August 25, 2025

NSW Government Department of Planning, Housing and Infrastructure

I am writing regarding project **SSD-3846-Mod-1 – West Culburra**. I've raised the below concerns throughout the various stages of the proposed development (refer attached), however have seen minimal amendment to address the shortcomings of the proposed design. Subsequent to my previous submissions the following concerns are raised in relation to the proposed water quality treatment.

EASTERN POND LAYOUT PLAN
SCALE 1:400

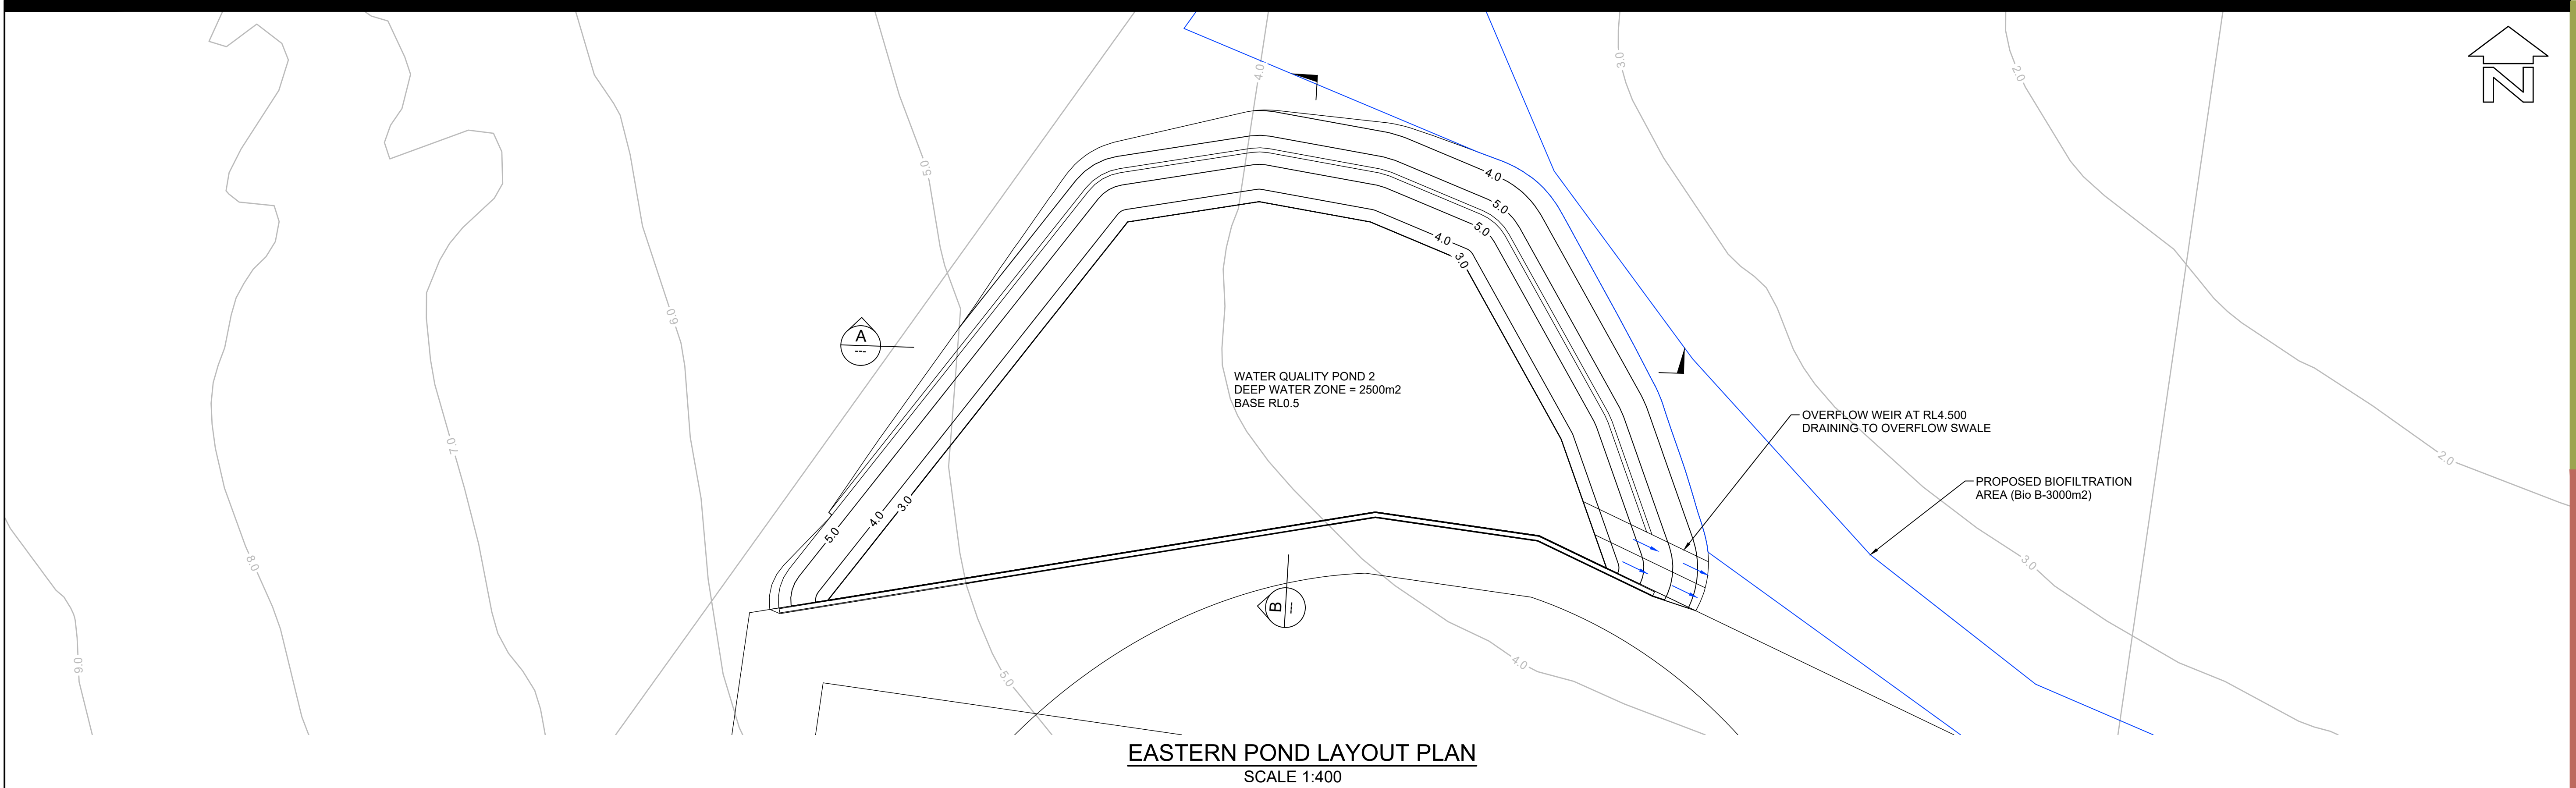
The proposed water quality control ponds and biofiltration are situated close to or within the 1% Annual Exceedance Probability (AEP) flood level (RL3.0 – note the error on Allan Price drawings this should be RL3.6 as per the flood certificate), as indicated on the concept design. Pond areas range from 250 m² to 2204 m², with varying proximity to sensitive foreshore and reserve areas.

Flood Inundation: The proximity to the 1% AEP flood line suggests a high likelihood of inundation during major storm events, which may compromise the ponds' ability to retain and treat stormwater effectively. The likelihood of inundation will increase as a result of climate change. If the Probable Maximum Flood level is adopted the ponds would be completely inundated.

Pollutant Resuspension: Flooding may lead to resuspension of captured sediments and nutrients, reducing treatment efficiency and potentially impacting downstream water quality i.e. sensitive coastal wetlands, marine and native vegetation of Curleys Bay and subsequently Crookhaven River.

Design Vulnerability: Without elevation or protective features, the ponds may not meet long-term performance objectives, especially under future climate scenarios.

- **Elevation Adjustments:** Evaluate the feasibility of raising the pond bases or embankments above the 1% AEP level to reduce inundation risk.
- **Overflow Management:** Design controlled overflow pathways to prevent untreated water from entering sensitive environments. The ponds are located directly adjacent to the waterway and will overflow untreated water into a pristine environment

WATER QUALITY TREATMENT TRAIN TYPICAL SECTION
SCALE 1:50

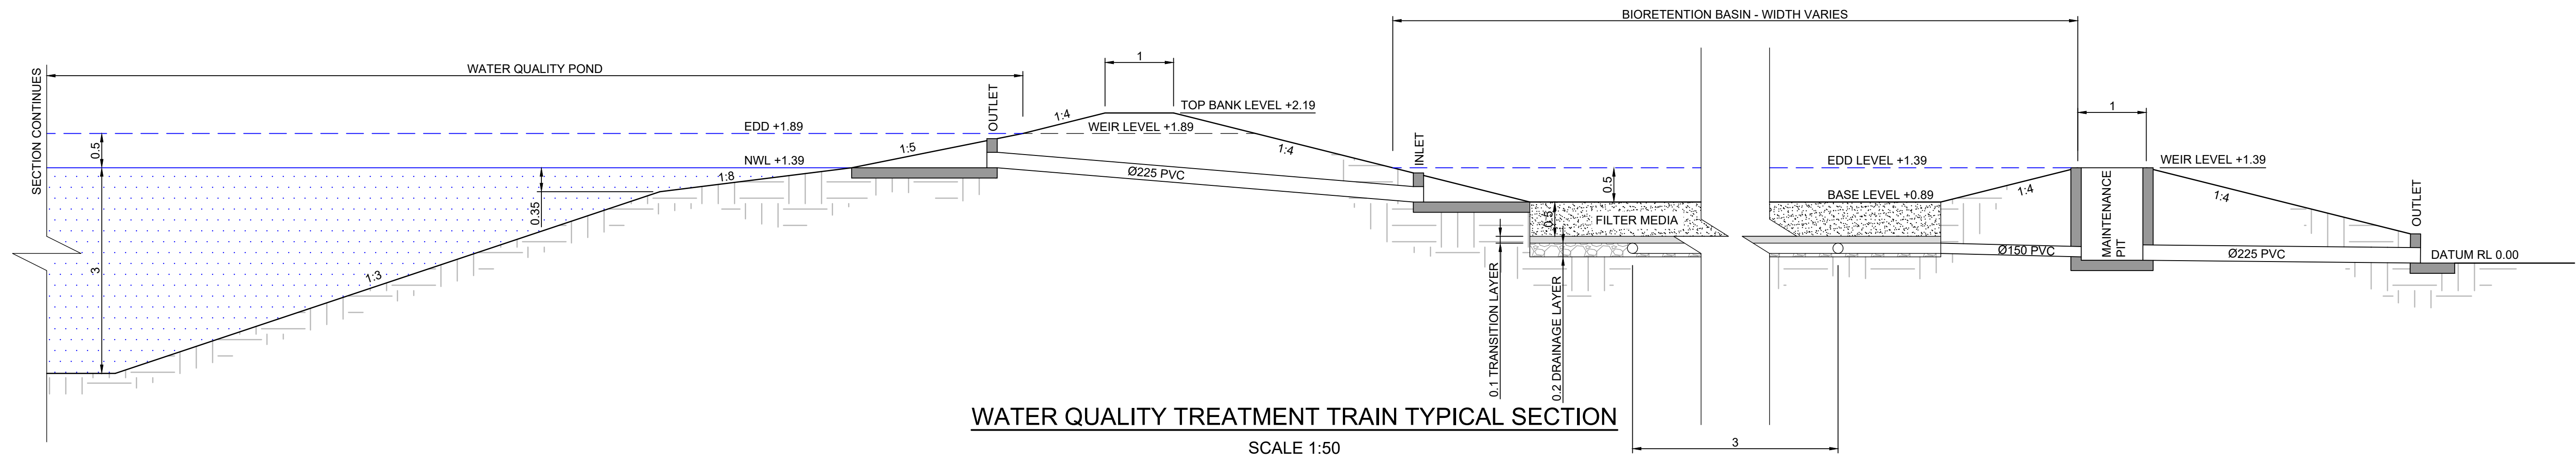
Flood Exposure: Biofiltration A and C are within the 1% AEP flood zone, which may reduce treatment efficiency during flood events due to:

- Inundation and bypassing of filtration media.
- Potential resuspension of captured pollutants.

Maintenance Challenges: Flood-prone biofiltration systems may require more frequent maintenance and sediment removal to remain effective.

- **Supplementary Treatment:** Consider integrating additional treatment systems (e.g., bioretention, constructed wetlands) in less flood-prone areas to provide redundancy. The concept has nominated biofiltration however the proposed location is within the flood effected area and will result in the biofiltration being ineffective.
